**Consultation Response from: KC Environmental Health (Pollution & Noise Control)**

**2024/92476 - Herbert Brown House, 50-52, Whiteley Street, Milnsbridge, Huddersfield, HD3 4LT**

**Discharge of details reserved by conditions 4 (noise assessment), 6 (ingress and egress) on previous permission 2024/90305 for change of use from Class B2 Industrial unit to Class E(d) Indoor sport & recreation (cricket coaching facility) (within a Conservation Area)**

**Responding Date:  
26 September 2024**

**Figure 1 – Aerial Photograph**

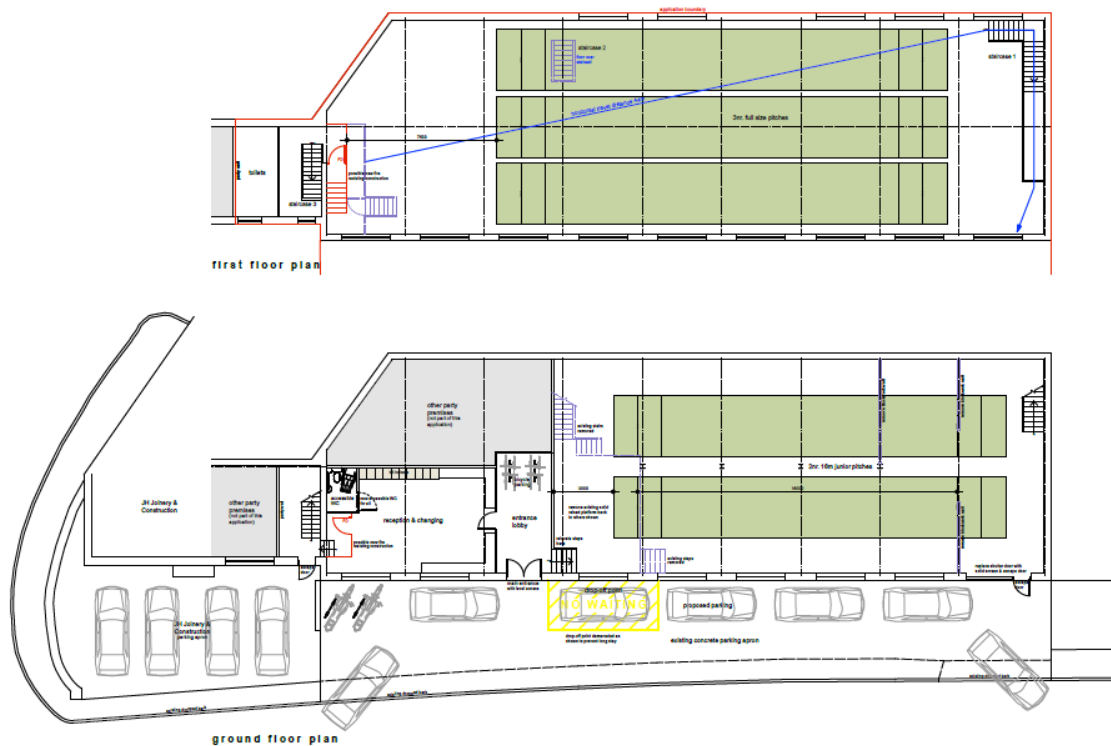
The applicant has submitted a Noise assessment authored by Martin Environmental Solutions dated August 2024 Ref 2784-1. Para 1.2 of the report identifies the neighbouring area as shown in figure 1 with particular reference to the residential noise sensitive receptors (NSRs).

The findings of the report are accepted.
